# Rezoning Transportation Analysis

Petition Number: 2022-114

## Revision Log:

Date	Description
12-28-22	First Review (TM)
03-23-23	Second Review (TM)
05-24-23	Third Review (TM)

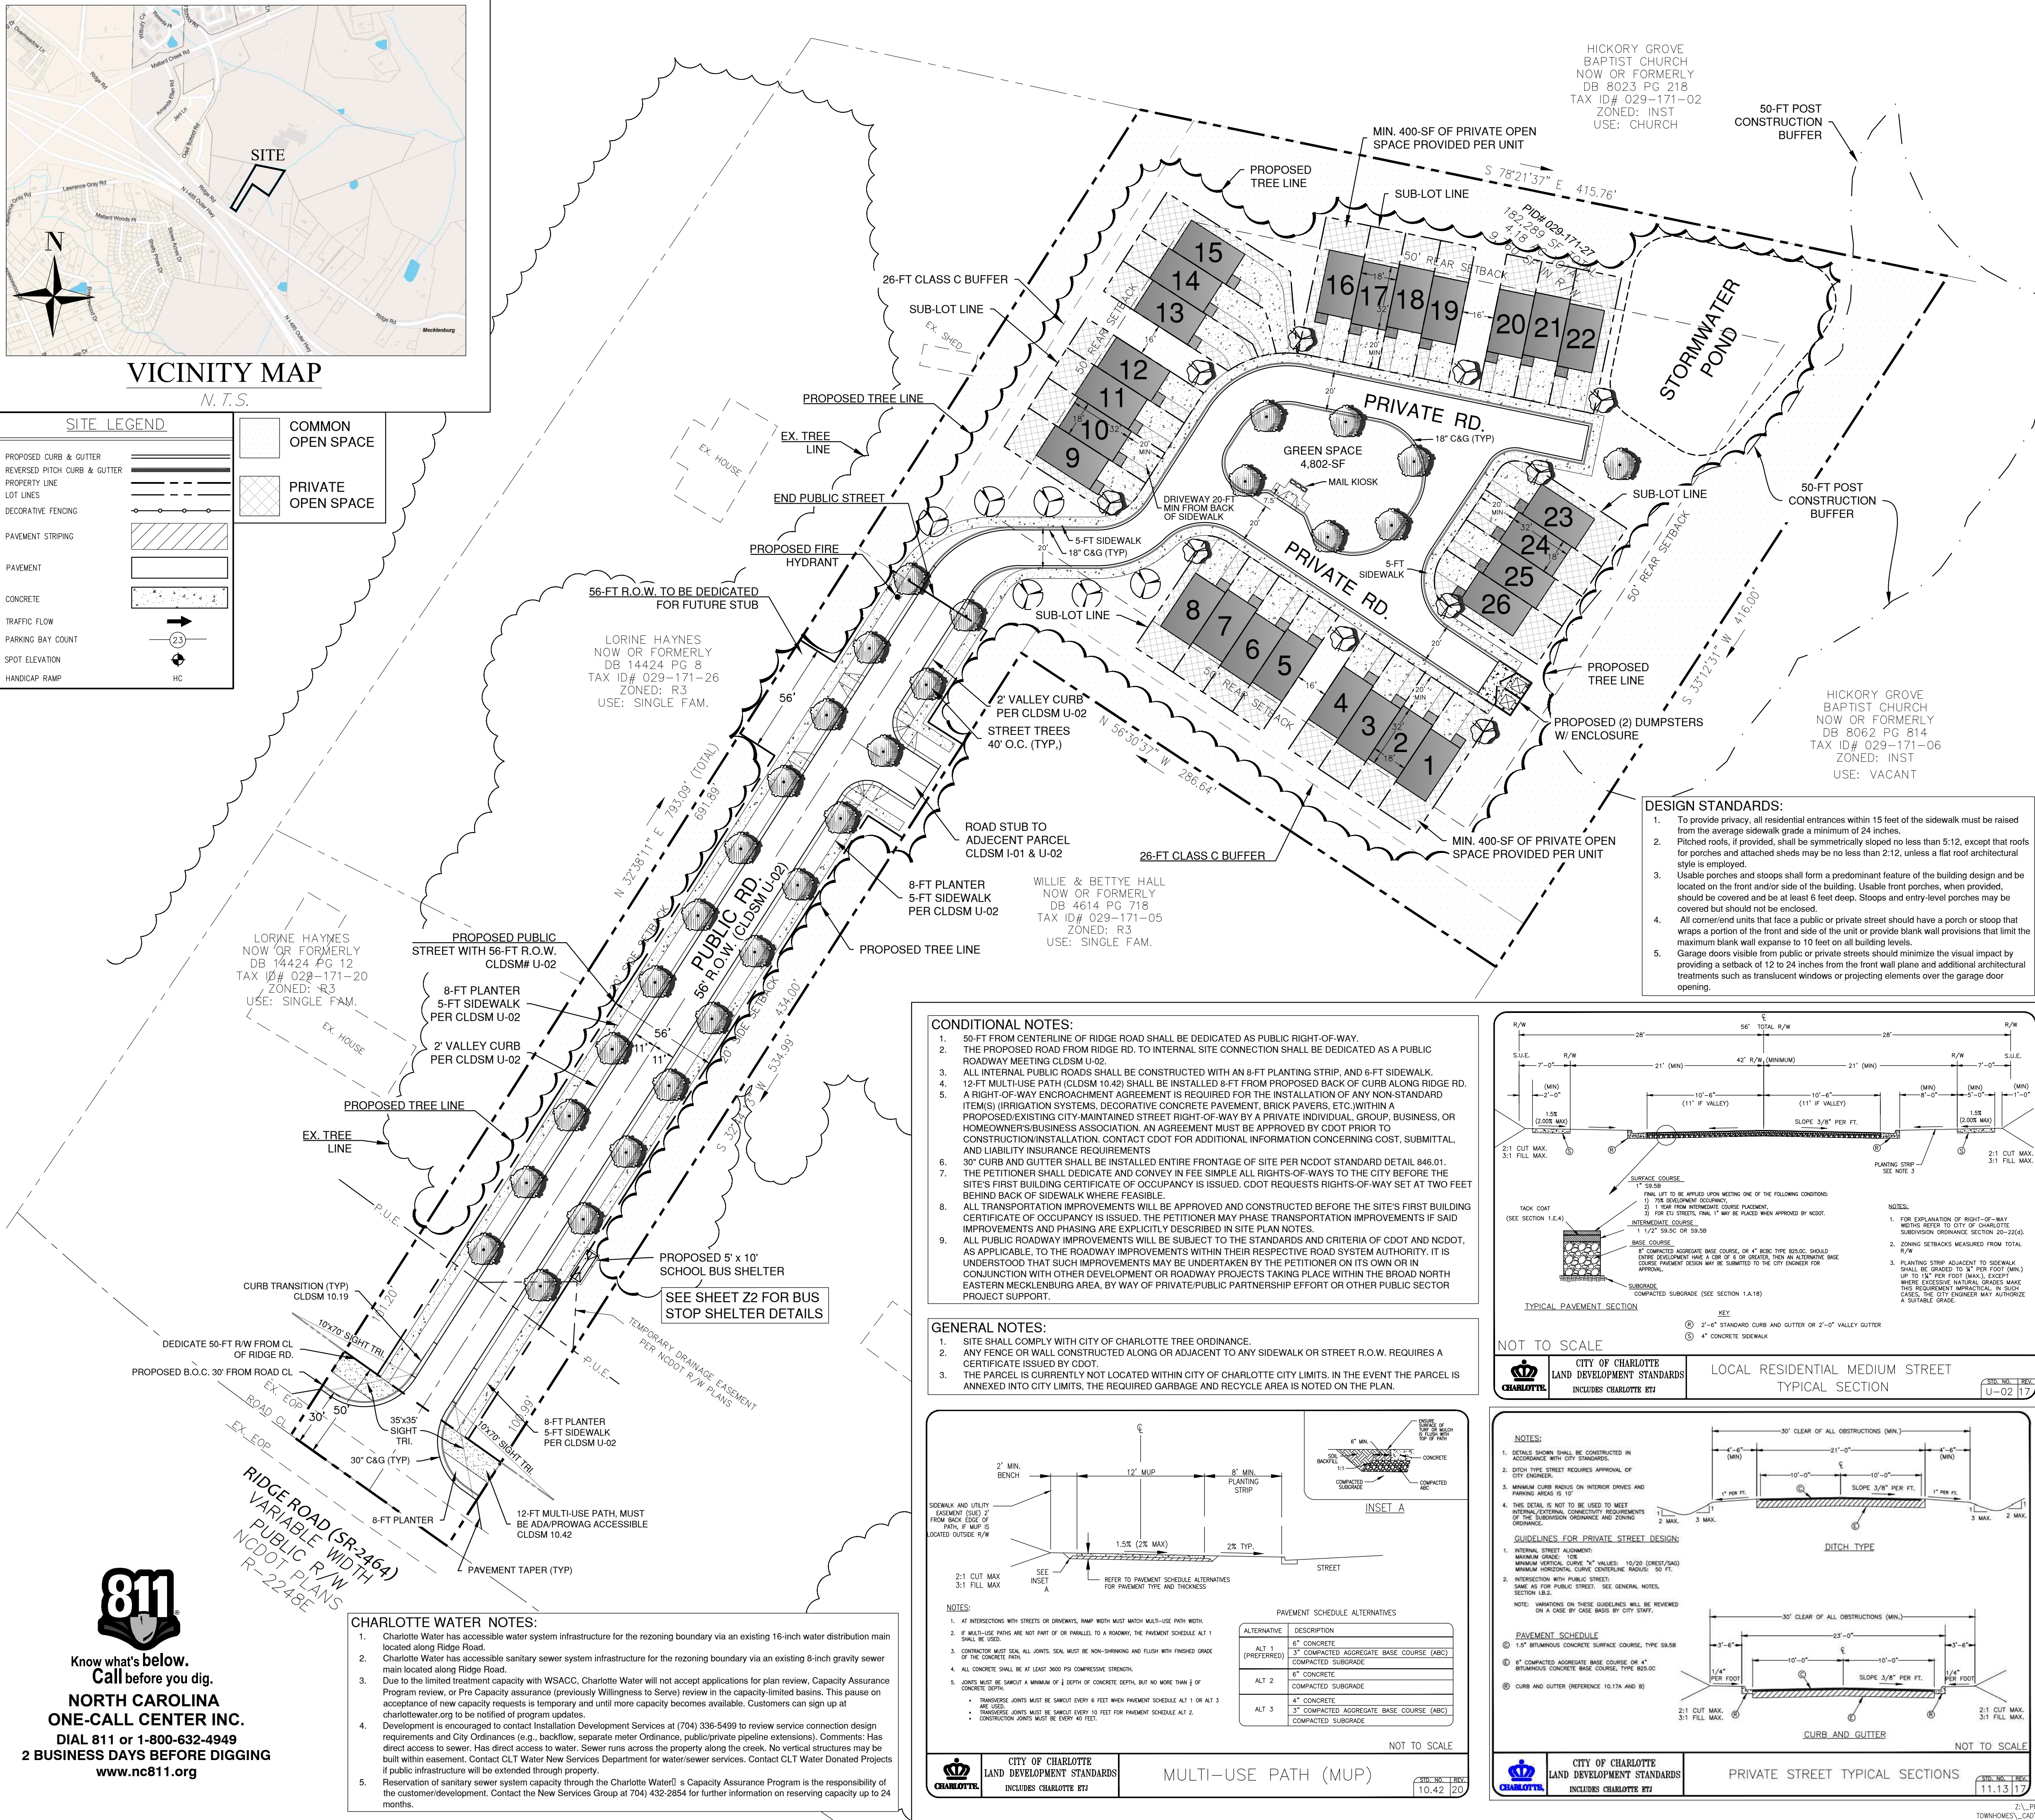
- a. ~~**Ridge Road:** Future back of curb and gutter to be located 30 feet from roadway centerline to accommodate the Charlotte Streets Map with a roadway typical section of CLDSM 11.09 Major Thoroughfare.~~

~~Label and dimension the future curb and gutter from the centerline for each road on the site plan.~~

### 3. ~~Revise site plan and conditional note(s) to commit to dedicate 50 right of way from the road centerline. The site plan shall label and dimension the right of way from the road centerline.~~

### 4. ~~Revise site plan and conditional note(s) to commit to constructing the proposed private road as a public roadway meeting CLDSM U-02 to be dedicated from Ridge Road to the internal site connection. Right of way should be dedicated to the property line along this public roadway to provide future access to adjacent parcels.~~

### 5. ~~Revise site plan and conditional note(s) to commit to construct an 8-foot planting strip, and 6-foot sidewalk on all internal public roads per Chapter 19. The site plan shall label and dimension both items from the back of curb and gutter or edge of pavement.~~

### 6. ~~Revise site plan and conditional note(s) to commit to construct bicycle facilities by locating the curb and gutter 30' from the center line/installing a 12' multi-use path 8' behind the back of curb to meet the Council adopted Charlotte BIKES Policy. Multi-use path shall meet ADA/PROWAG requirements.~~

- ~~8. Revise site plan and conditional note(s) to commit to constructing standard 2-foot 6-inch curb and gutter across the entire frontage of the site.~~
